Application number: 2023/91228	
What is the application for?:	Demolition of existing bungalow and garage and erection of detached dwelling and
Address of the site or building:	64, Westfield Lane, Scholes, Cleckheaton, BD19 6DR
Postcode:	BD19 6DR

NORTH ELEVATION

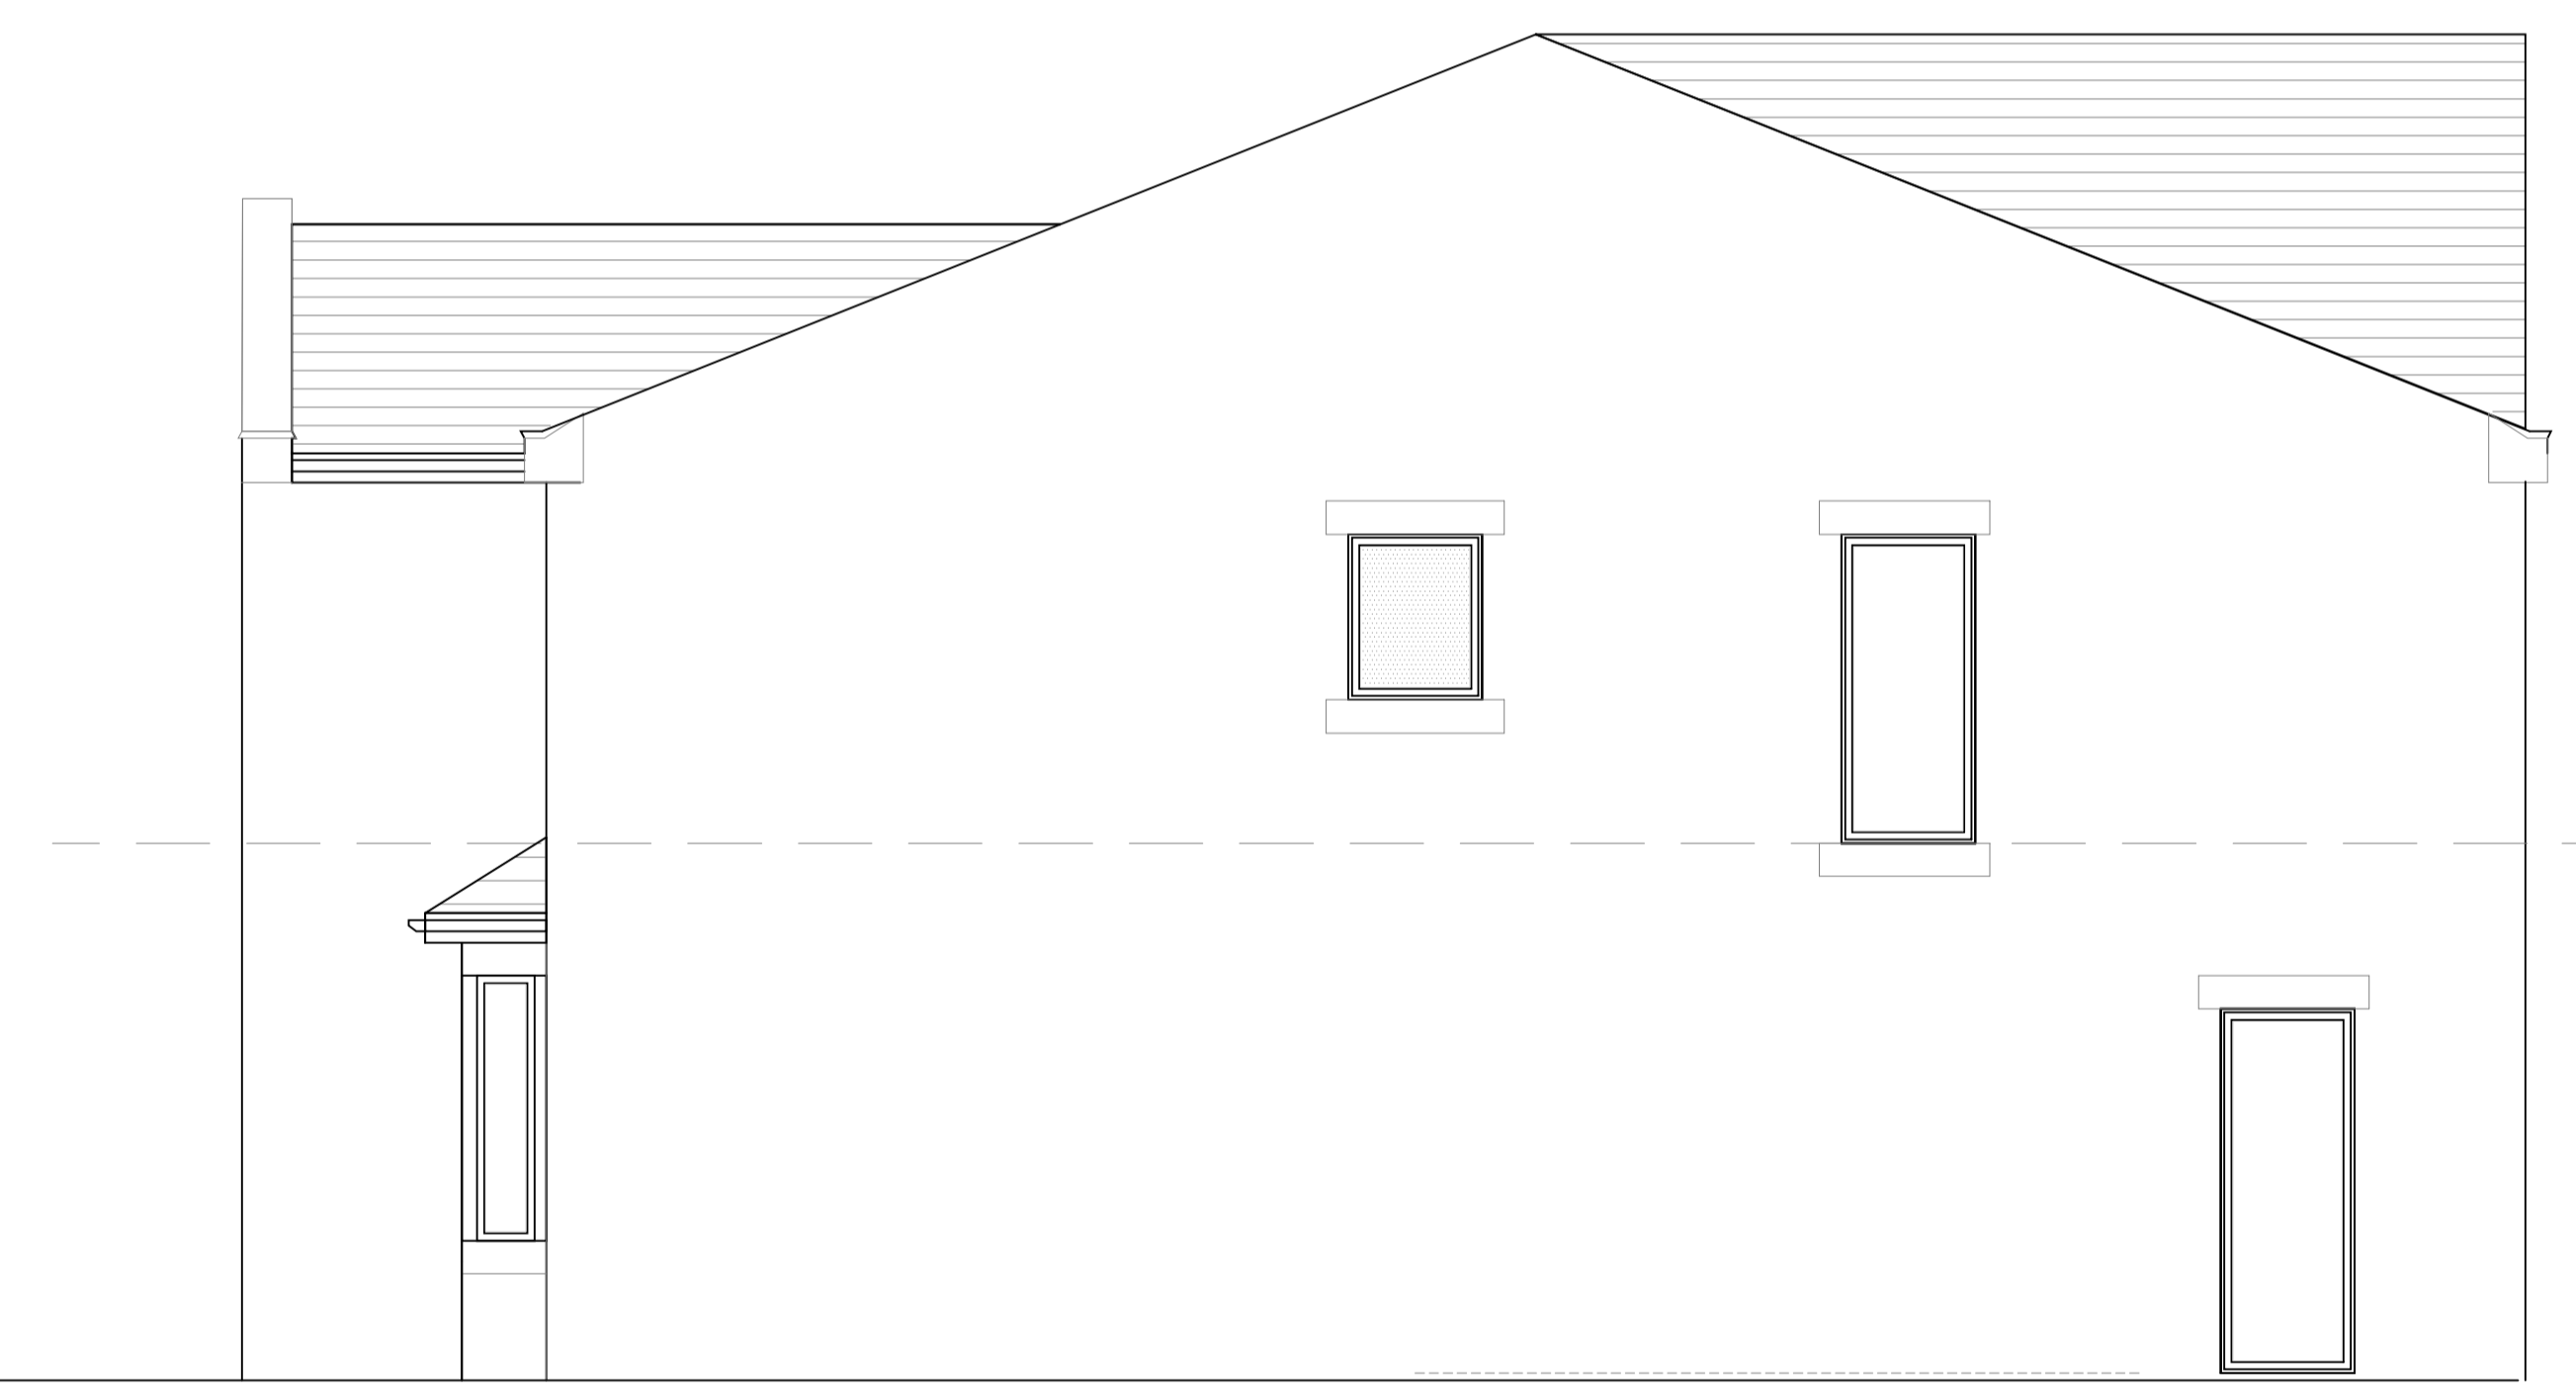
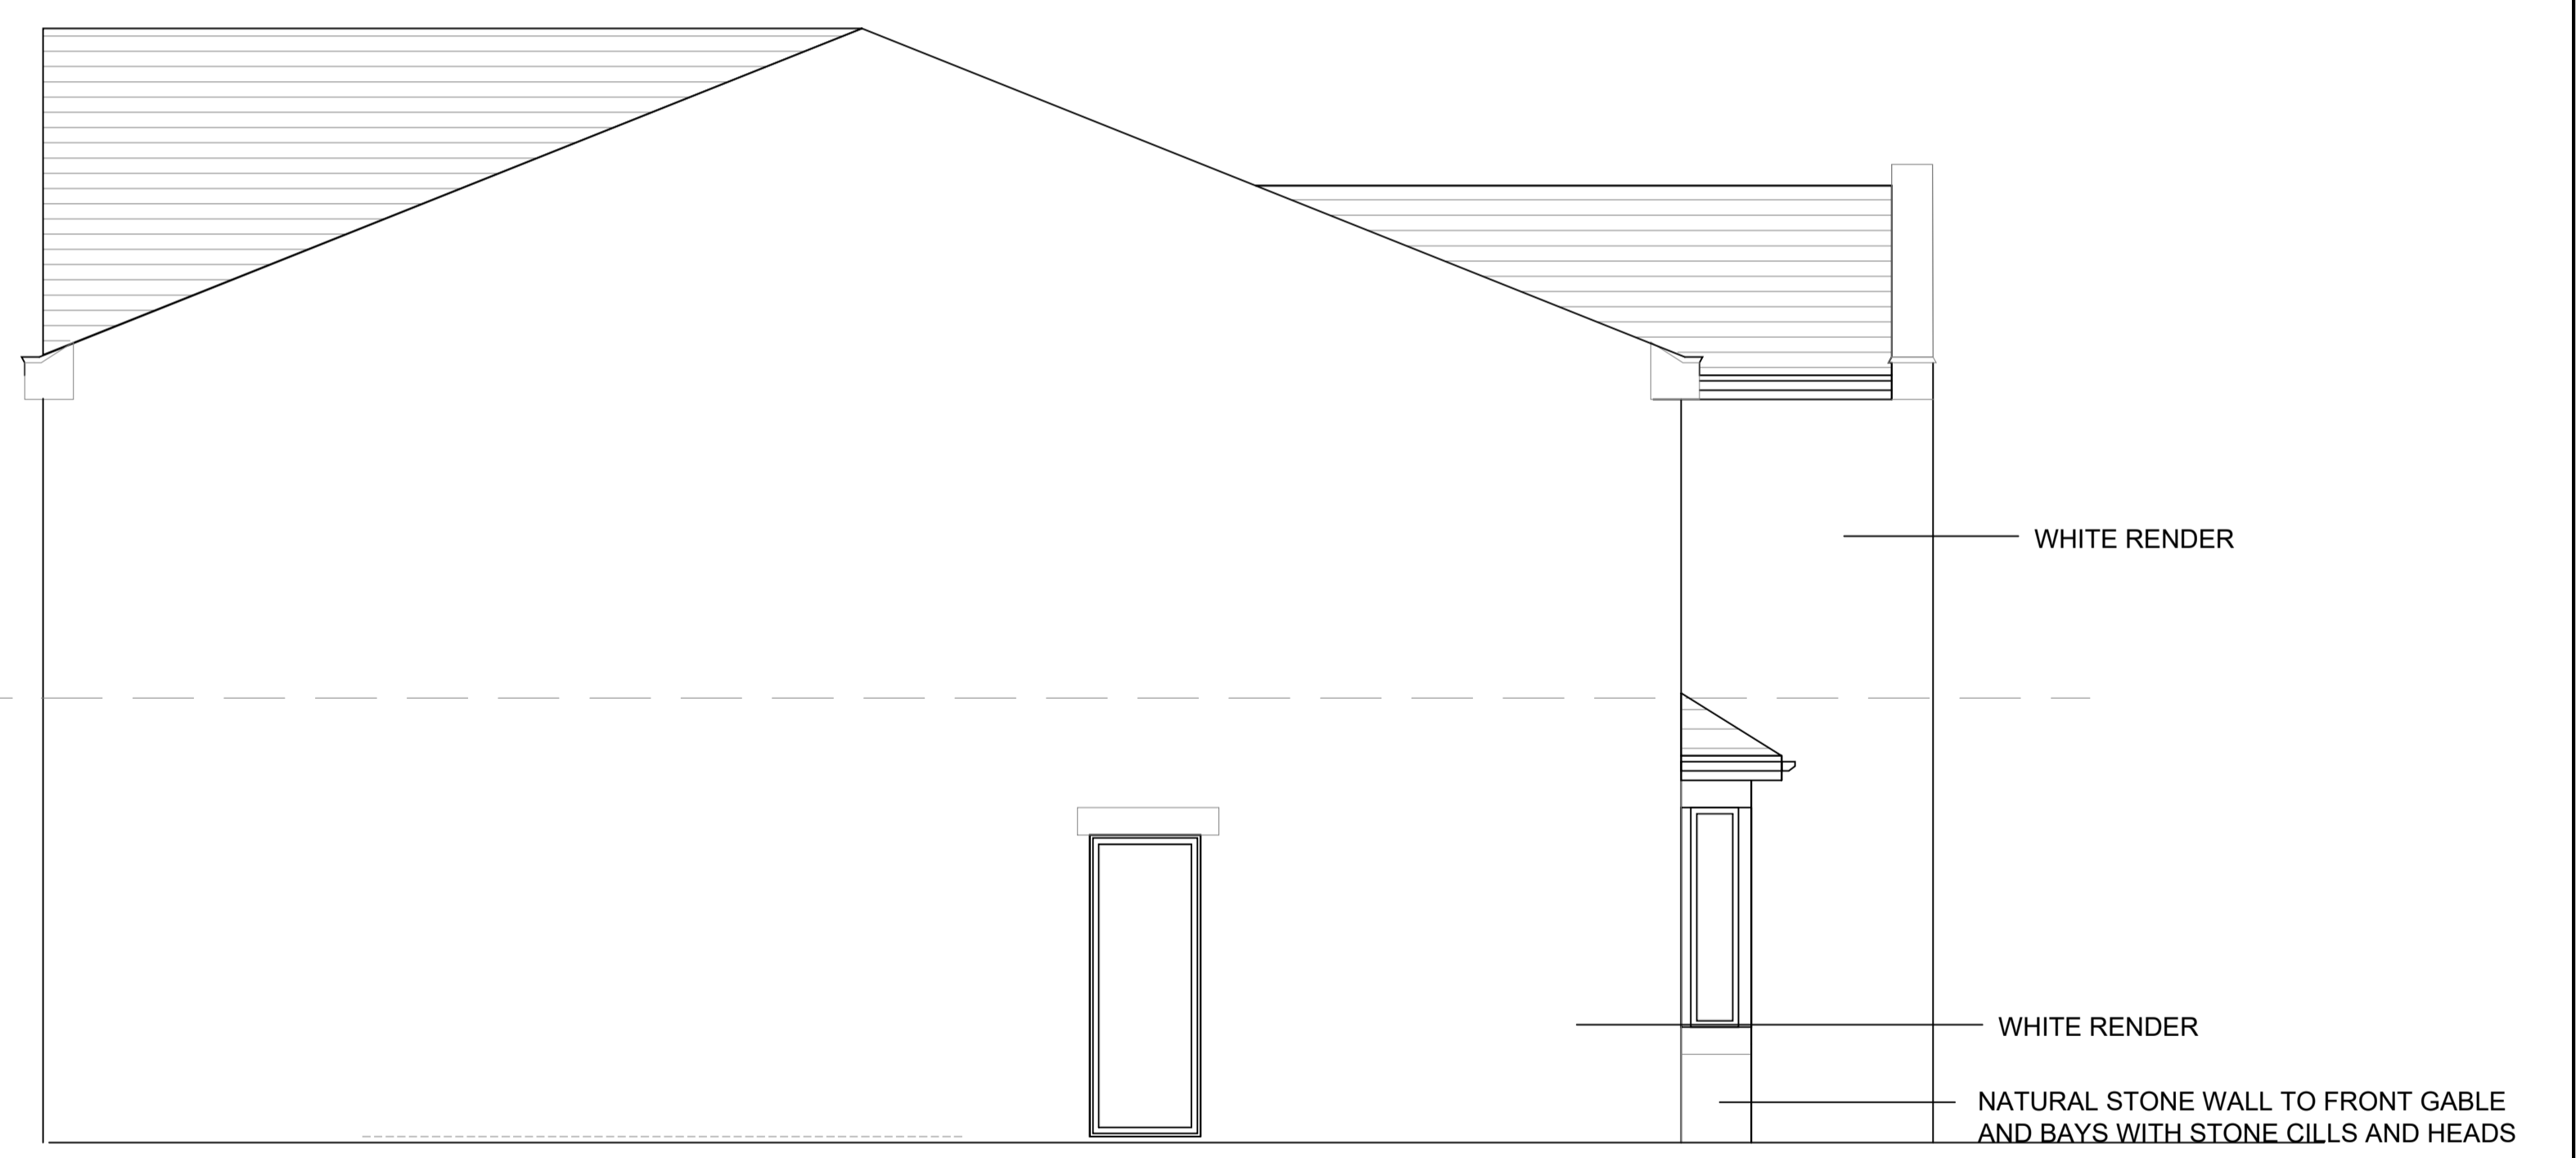
Type of comment: An objection	
Do you wish your comments to be published on the website anonymously?	Yes
<p>I object to this application because of the large first floor window and balcony on the northern elevation. I feel this would adversely affect the privacy of neighbouring properties.</p> <p>When previous plans for this property were approved it was stipulated that no additional doors and windows could be added so that the privacy of the neighbours was preserved. The proposed window and balcony would be far more intrusive than those permitted under the previous plans.</p> <p>I would also ask that restrictions relating to hours of work and noise are applied to this planning application</p>
